Thurrock Power Ltd Comments on Historic England's Deadline 2 Submission

Deadline 3

- 1.1.1 This document provides the applicant's comments on matters raised in Historic England's Written Representation at Deadline Two (REP2-084): effects on the Grade I listed Church of St Katherine and the Grade II listed Old Rectory; consent for trial trenching under section 38 of the Commons Act 2006; and the risks involved with undertaking archaeological field surveys at the post-consent stage.

Thurrock Flexible Generation Plant Statutory and Non-Statutory Sites or Features of the Historic Environment

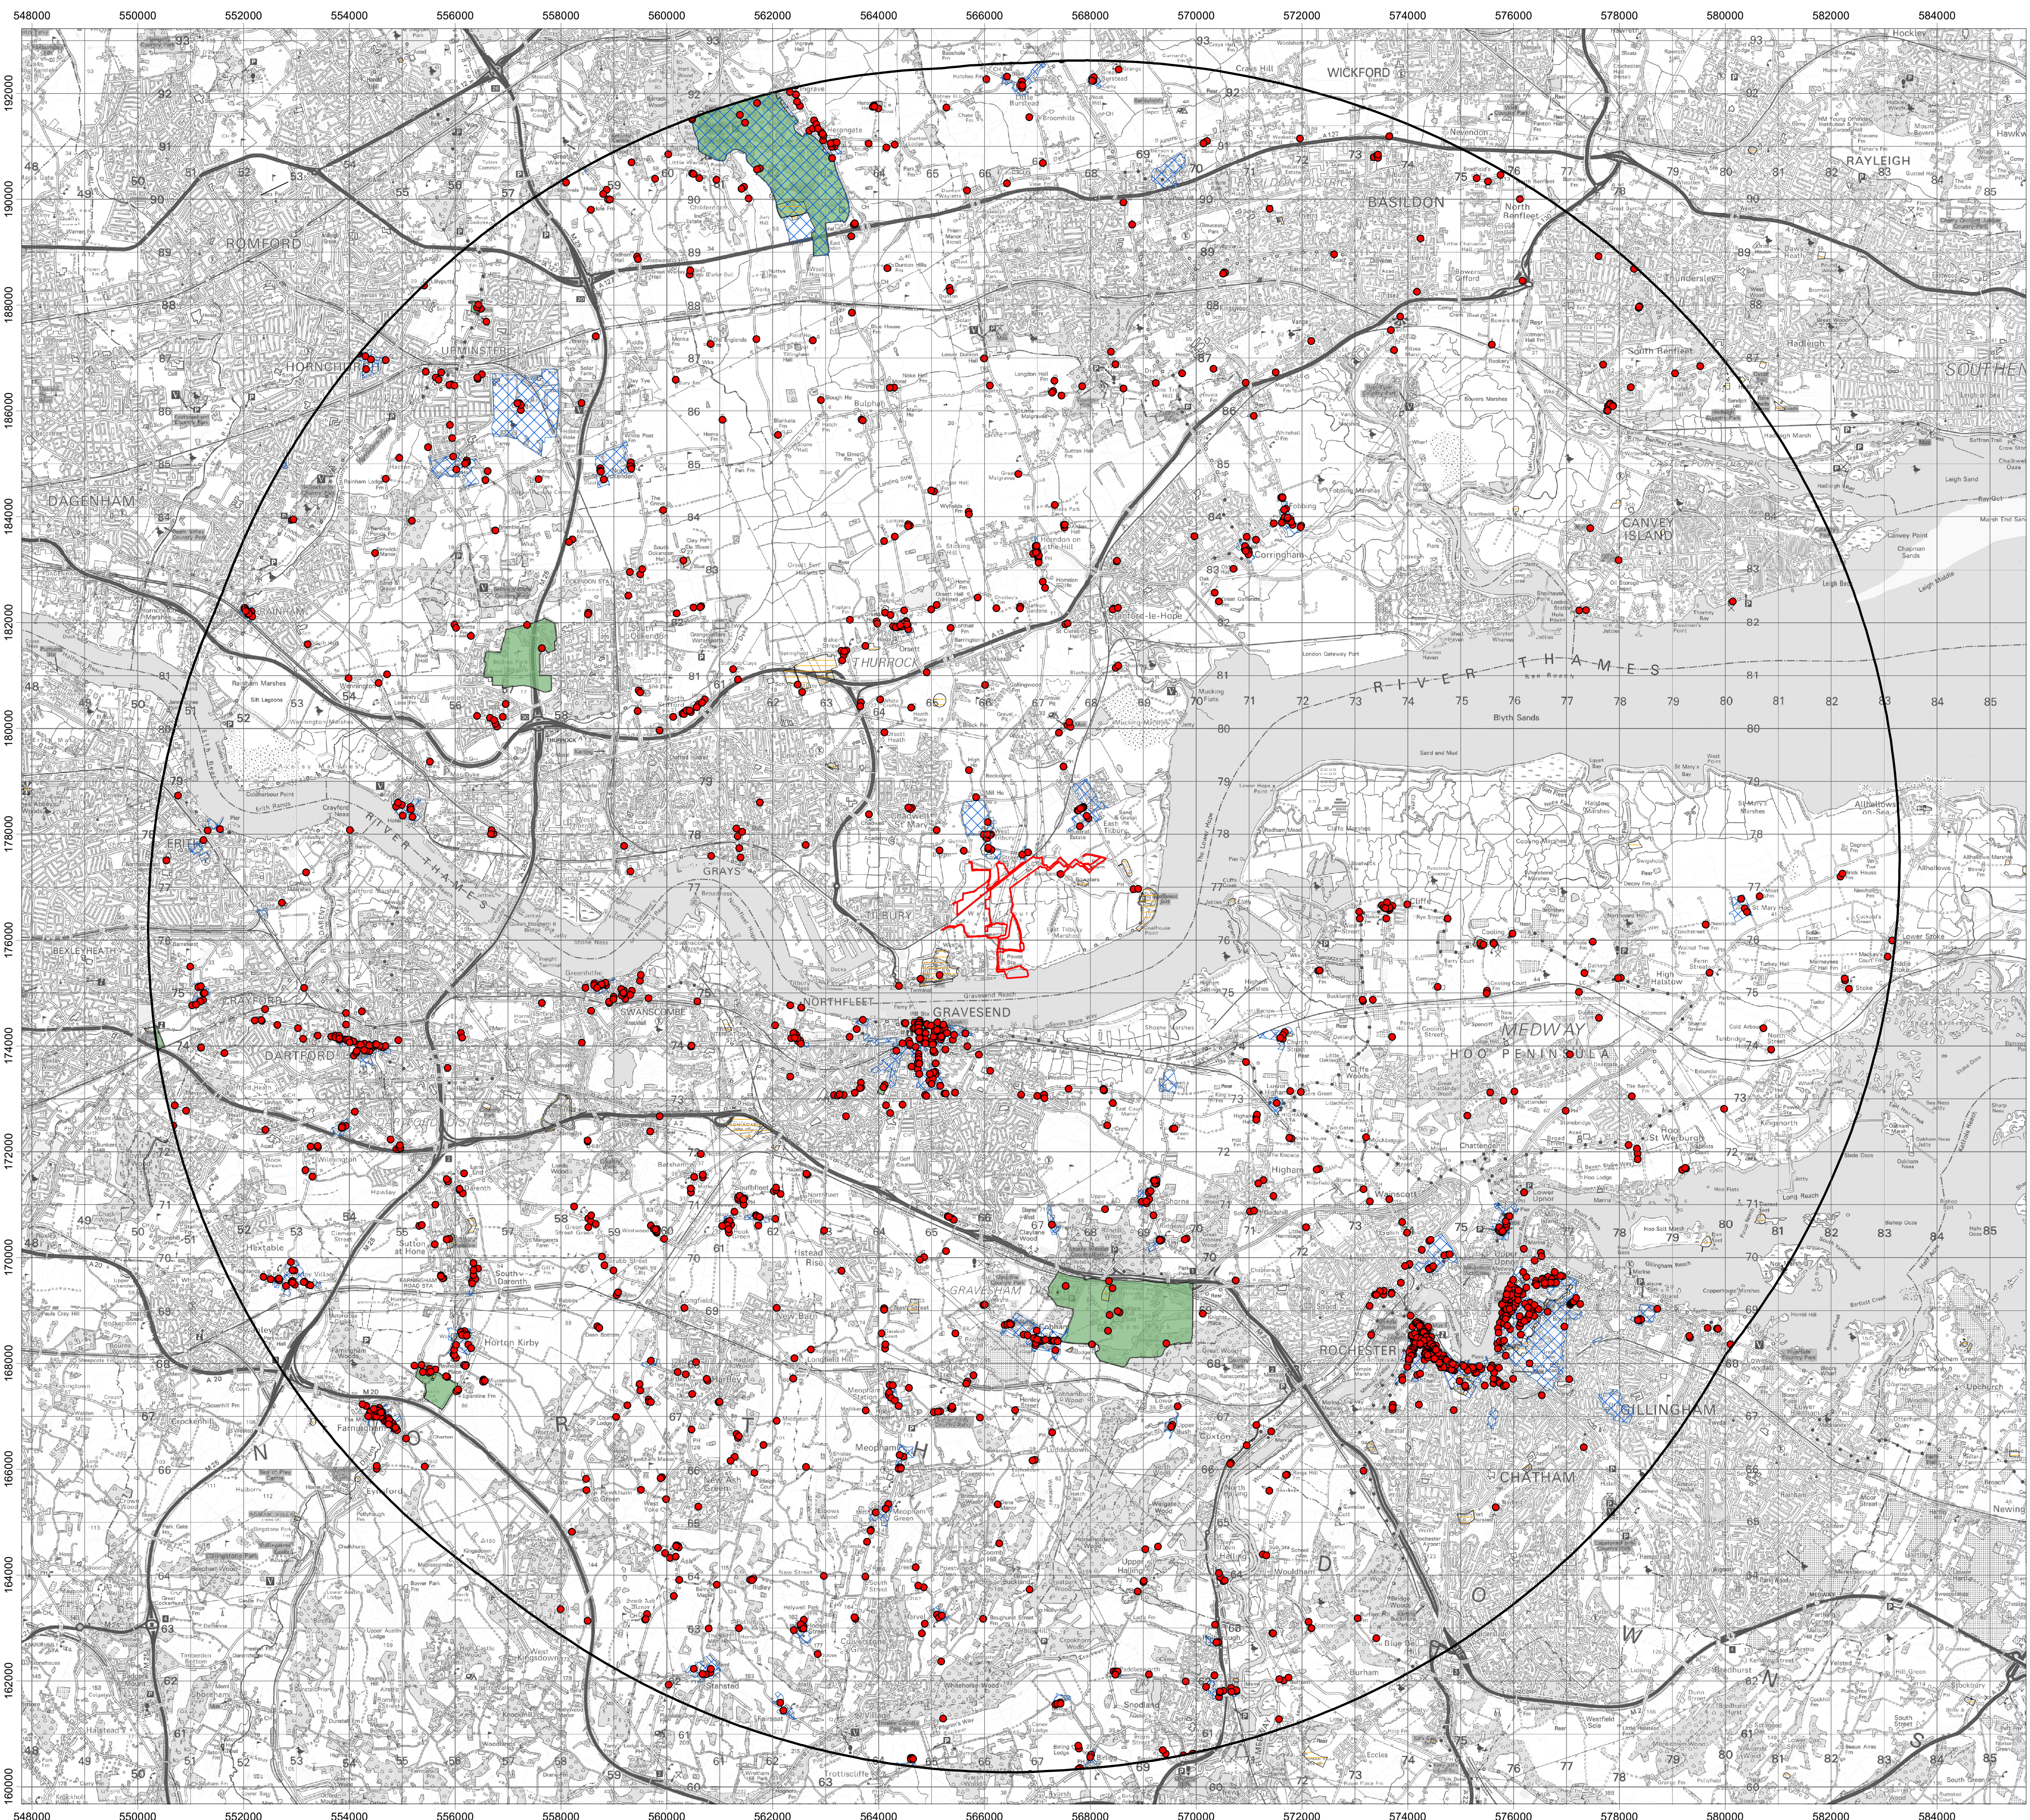
- 1.2.1 On page 12 of the representation Historic England (HE) has commented that Figure 2.6: Landscape and Visual Impact Assessment ZTV and 10 km Study Area (Chapter 6: Landscape and Visual Resources of the May 2020 ES) shows that the Grade I listed Church of St Katherine is within the zone of theoretical visibility, therefore this church and the nearby Grade II listed Old Rectory should not have been scoped out of the initial assessment.

- 1.2.2 The applicant can confirm that the Grade I listed Church of St Katherine is not within the zone of theoretical visibility (ZTV) for the proposed development. The image below shows the relevant part of the ZTV, with the Grade I listed Church of St Katherine shown as a red triangle and the Grade II listed Old Rectory as a green triangle. The areas shaded in green in the image are those from which some or all of the proposed development would be visible. This lack of intervisibility, along with the observation that the proposed flexible generation plant development site does not make a meaningful contribution to the setting of either of the two listed buildings, justifies their exclusion from the initial assessment.

- 1.2.3 Following consultation with HE on 10th February 2021, additional assessment has been undertaken with regard to the Grade I listed Church of St Katherine and the nearby Grade II listed Old Rectory. The results of this additional assessment were presented in the applicant's Deadline 2 Response to Examination Question HER-2 Historic Environment Information (REP2-054).
- 1.2.4 Verified photos and wirelines taken from the vicinity of the Grade I listed Church of St Katherine and the nearby Grade II listed Old Rectory Heritage demonstrated that the proposed Thurrock Flexible Generation Plant development would have no impact on the significance of either these designated heritage assets. This is shown in the images from Heritage Viewpoints 4a and 4b,
